**Tillbridge Solar Project
EN010142**

**Change Request Report
Document Reference: EN010142/APP/8.1**

**September 2024
Revision Number: 00**

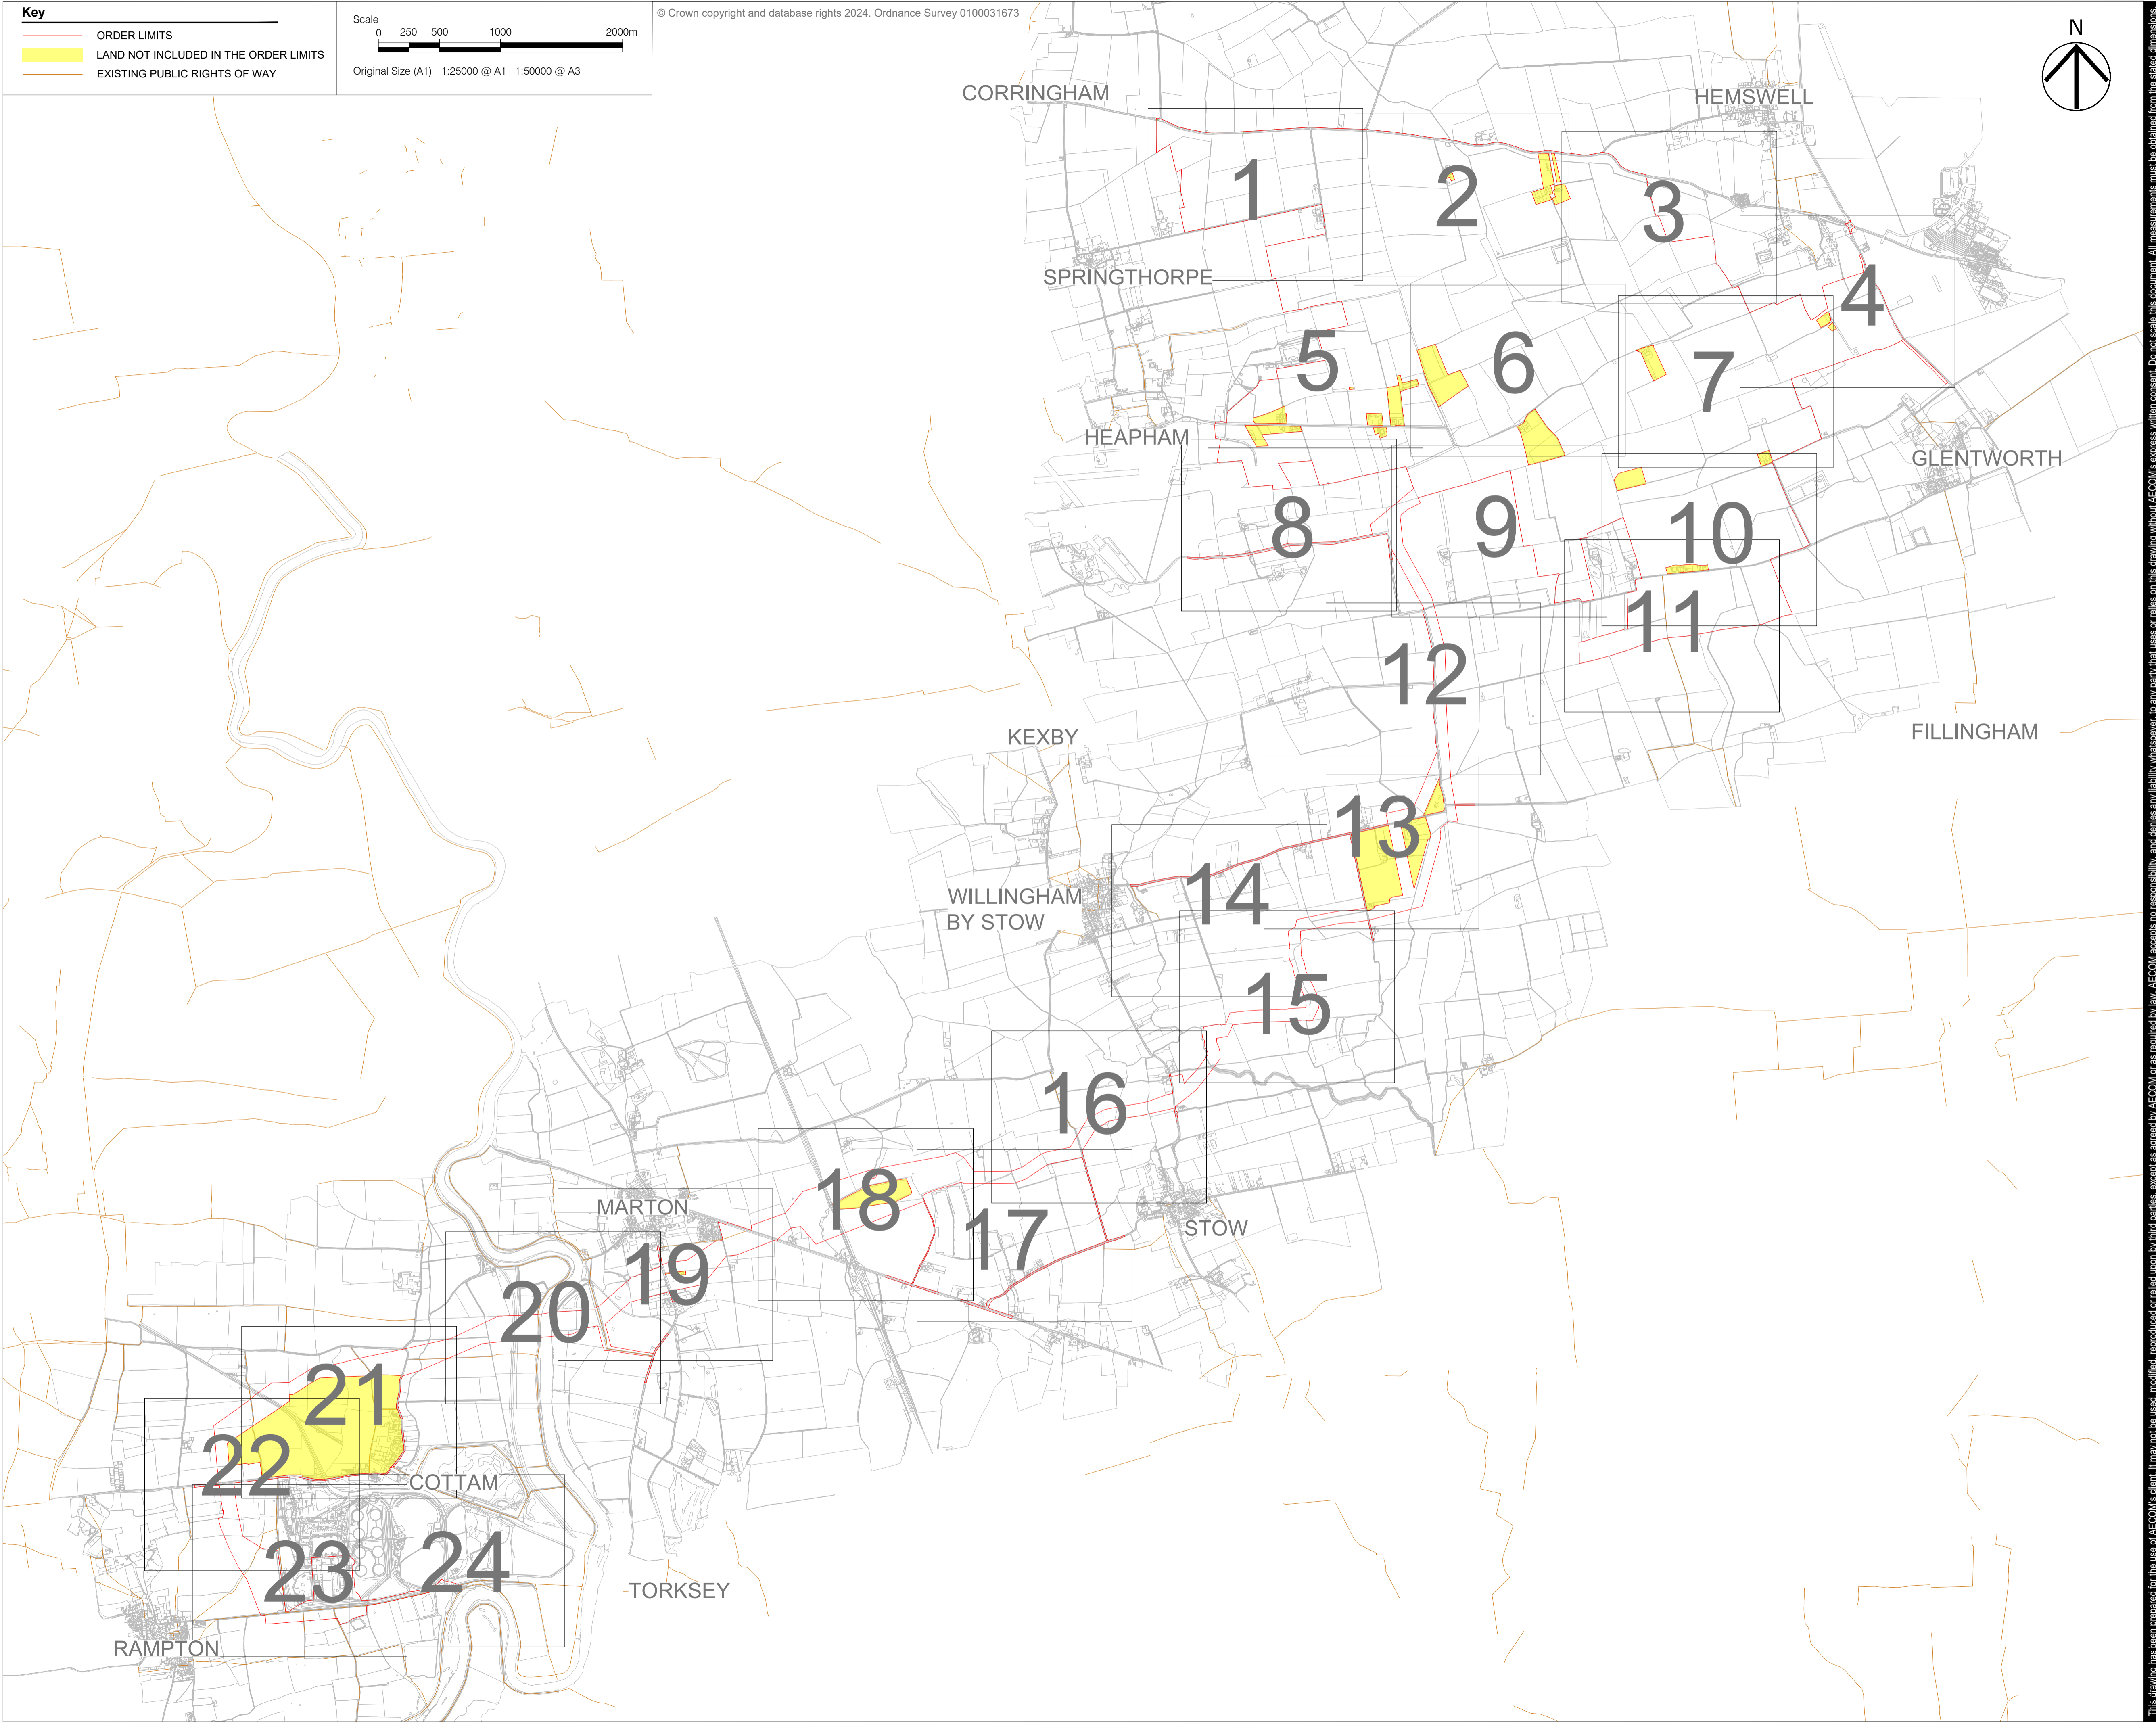
- a. Change 5 now includes a minor amendment to the proposed position of access 1/14 as shown on Sheet 1 of 24 of the **Streets, Rights of Way and Access Plans [EN010142/APP/2.4 (Rev02)]**. This minor layout change was not identified at the time of the Change Notification and is a consequence of incorporating the second access to serve the proposed substation to create a one-way access and egress arrangement. This is explained in more detail below.

- 2.2.3 Change 5 relates to further design iteration with the inclusion of two new access points to be provided off School Lane. One access (Access 1/35 as shown on Sheet 1 of 24 of the **Streets, Rights of Way and Access Plans [EN010142/APP/2.4(Rev02)]**) will be to serve a construction compound associated with the 400kv internal cable route corridor within the Principal Site and the other access (Access 1/34 as shown on Sheet 1 of 24 of the **Streets, Rights of Way and Access Plans [EN010142/APP/2.4(Rev02)]**) will be to provide a second access to be used during the construction and

operation of Substation B. This will create a one-way system in conjunction with the single point of access (Access 1/14 as shown on Sheet 1 of 24 of the **Streets, Rights of Way and Access Plans [EN010142/APP/2.4(Rev02)]**) that was originally proposed as part of the Application. This will allow vehicles to enter and exit the substation site in a forward gear and will improve manoeuvring within the Principal Site.

- 2.7.1 An additional temporary access will be provided off School Lane to the north of the proposed Access 1/14 for Substation B, referred to as Access 1/35, as shown on **Streets, Rights of Way and Access Plans [EN010142/APP/2.4(Rev02)]** to facilitate access to a temporary construction compound. A second permanent access will also be located north of Access 1/14, referred to as Access 1/34, to provide a second access to the proposed substation as shown on the **Streets, Rights of Way and Access Plans [EN010142/APP/2.4(Rev02)]**. In addition, the location of Access 1/14 has been moved slightly to the north of the original position as shown on the **Streets, Rights of Way and Access Plans [APP-008]**, to create a one-way system in conjunction an additional second access (Access 1/34 as shown on Sheet 1 of 24 of the **Streets, Rights of Way and Access Plans [EN010142/APP/2.4(Rev02)]**). Accesses 1/14 and 1/34 will provide a one-way system for Substation B allowing vehicles to enter and exit the substation site in a forward gear and will improve manoeuvring within the Principal Site. This minor re-alignment of Access 1/14 will provide a staggered junction to the west of Access 1/15 along School Lane offering an improved design as shown on Sheet 1 of 24 of the **Streets, Rights of Way and Access Plans [EN010142/APP/2.4(Rev02)]**.

- 2.7.2 The refined layout will mean that the substation is served by a one-way access system ensuring that construction and operational vehicles can enter and exit the substation safely. This change will not amend the Order limits and has arisen through further technical considerations and the need to segregate the movement of vehicles associated with the construction of the Cable Route Corridor and the construction of Substation B.
